From:
To: [DCAdmin](#)
Subject: Objection to planning application 2020/91522 - land at rear of 8 Grove Terrace, Birkenshaw, BD11 2LY
Date: 23 June 2020 13:33:07

Objection to planning application 2020/91522 - land at rear of 8 Grove Terrace, Birkenshaw, BD11 2LY

PROPOSED SITE PLAN

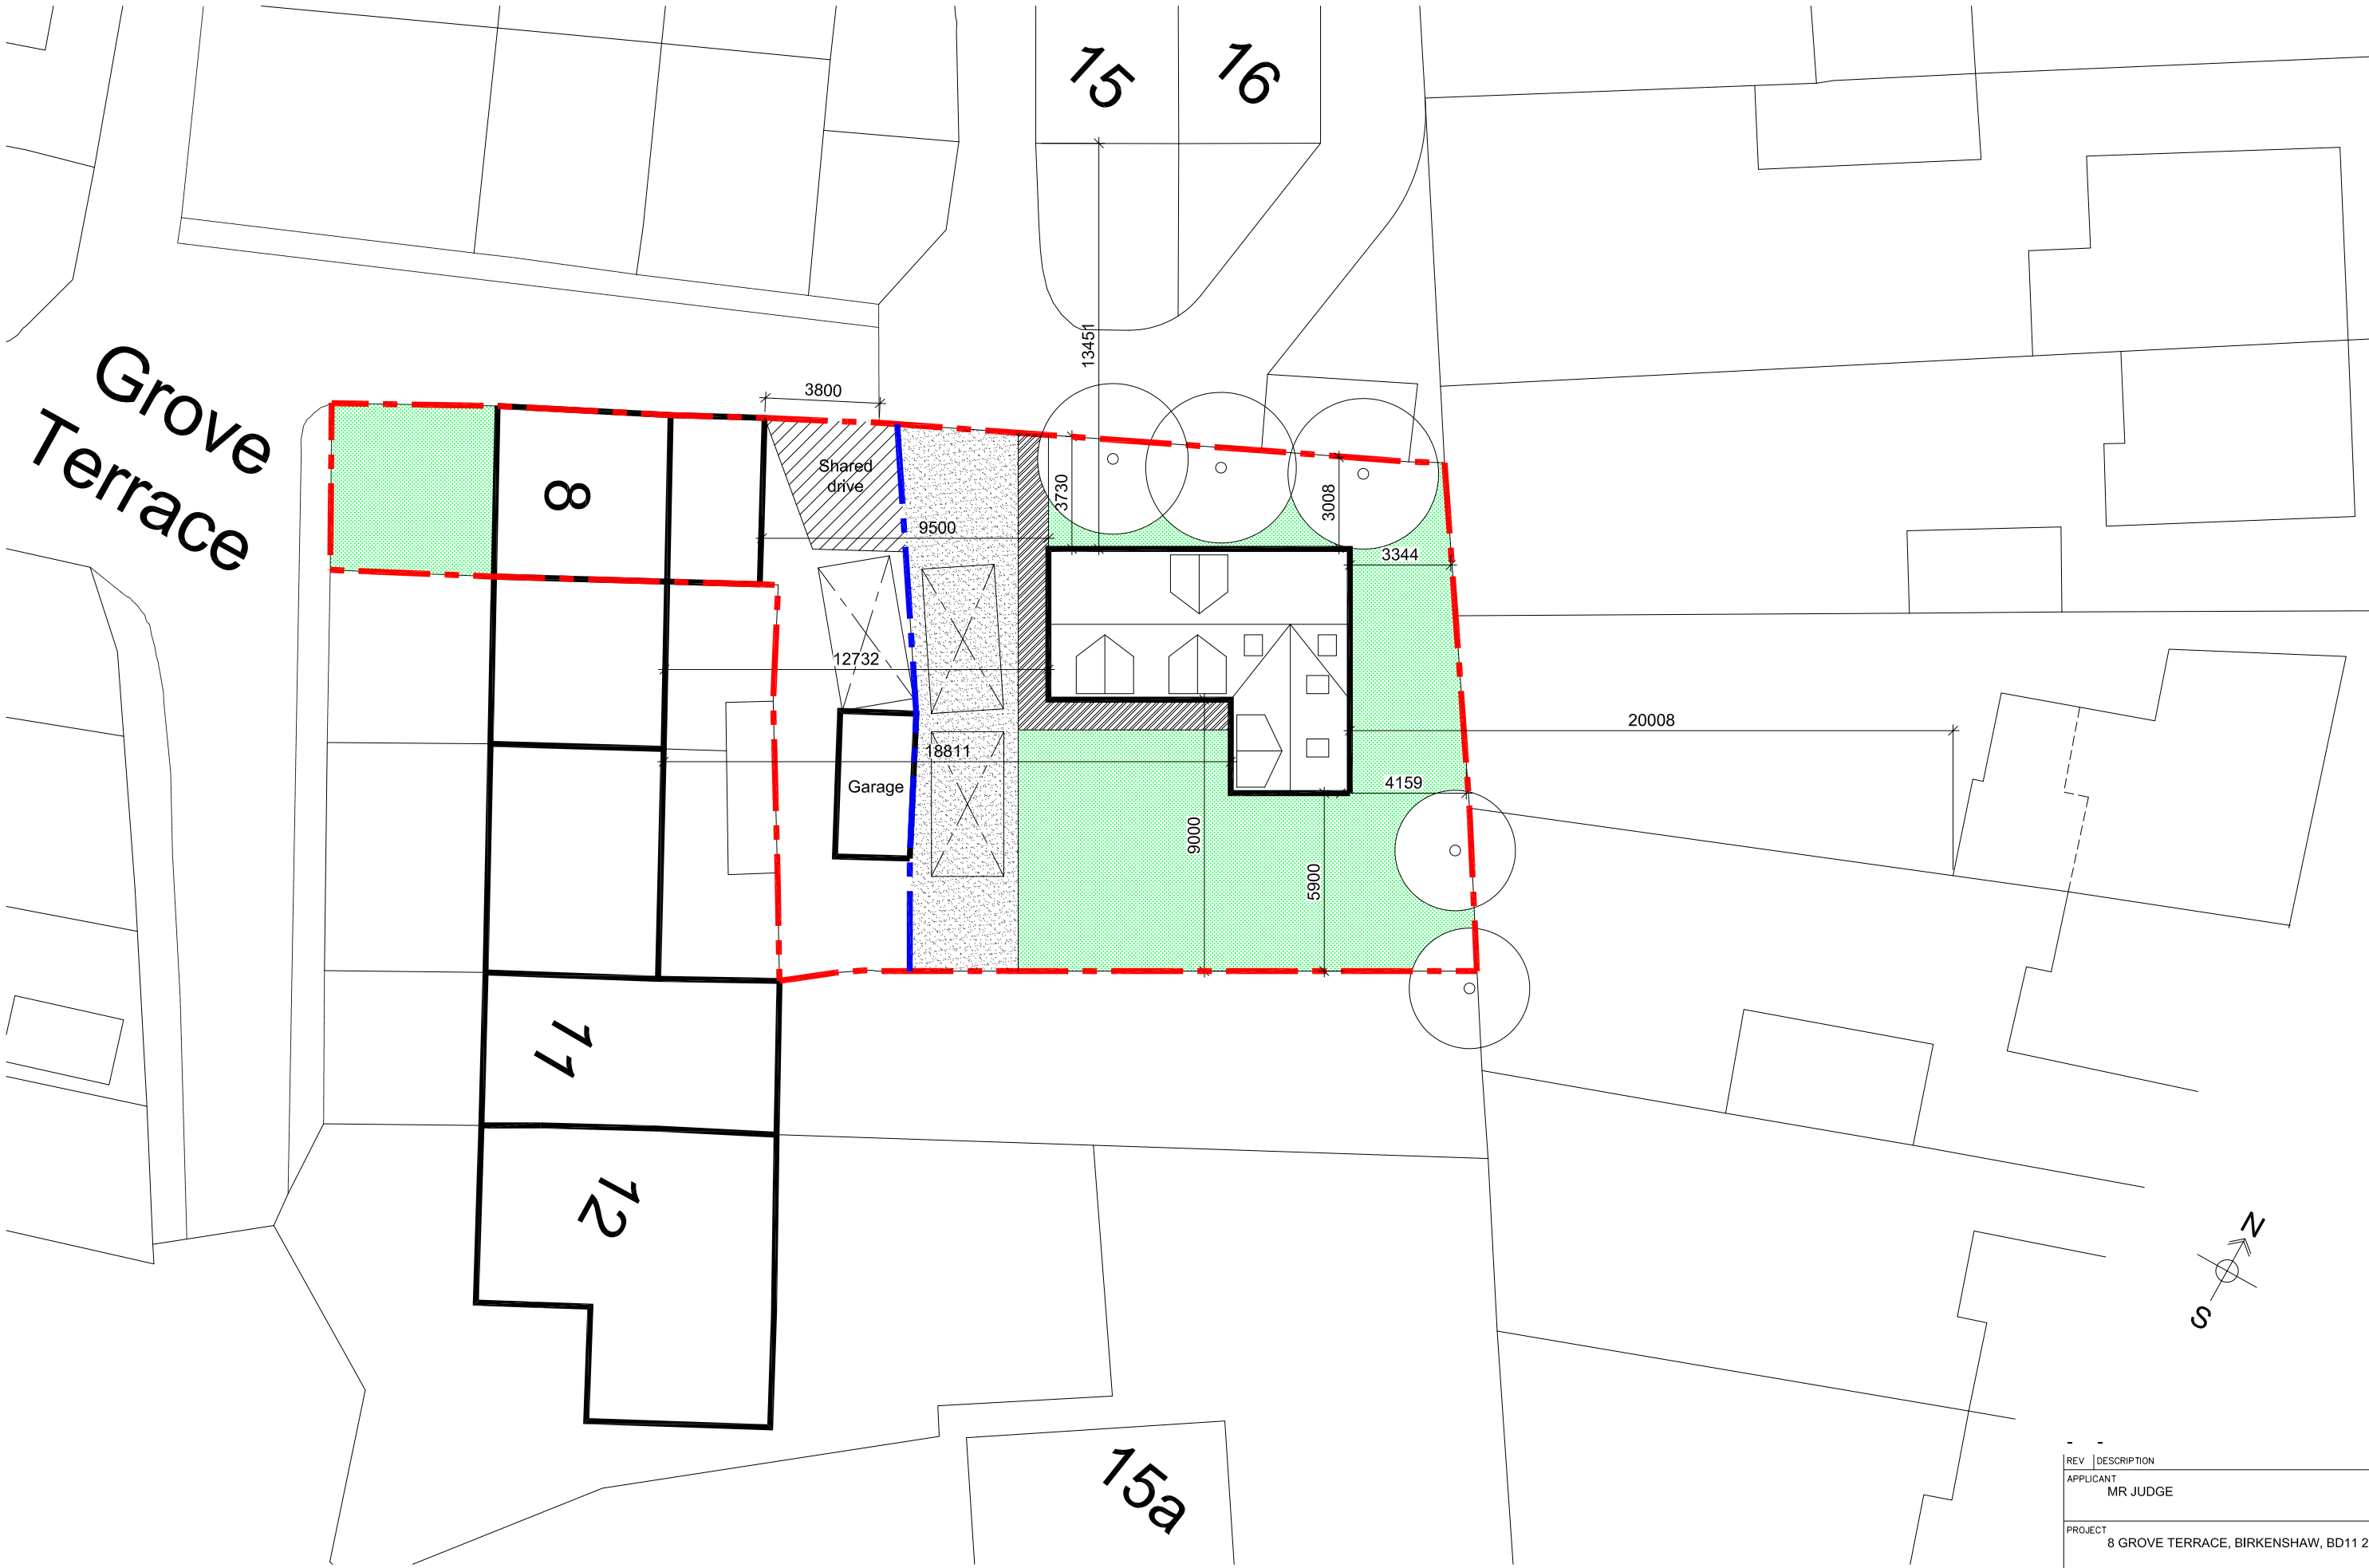
The current entrance to the land at 8 Grove Terrace is very narrow for large contractor vehicles and we cannot foresee how any large contractor vehicle could turn into the site without knocking down the wall belonging to 15/16 Grove Terrace and then accessing their site via private land belonging to 15/16. The boundary to the land is very clear.

Contractors would also be unable to access the site if cars are parked outside the properties adjacent to the entrance to 8 Grove Terrace. The cul-de-sac at the entrance to 8 Grove Terrace is simply not wide enough for easy access. Large contractor vehicles will not be able to access the site without encroaching on private land for which permission would have to be sought from the respective residents.
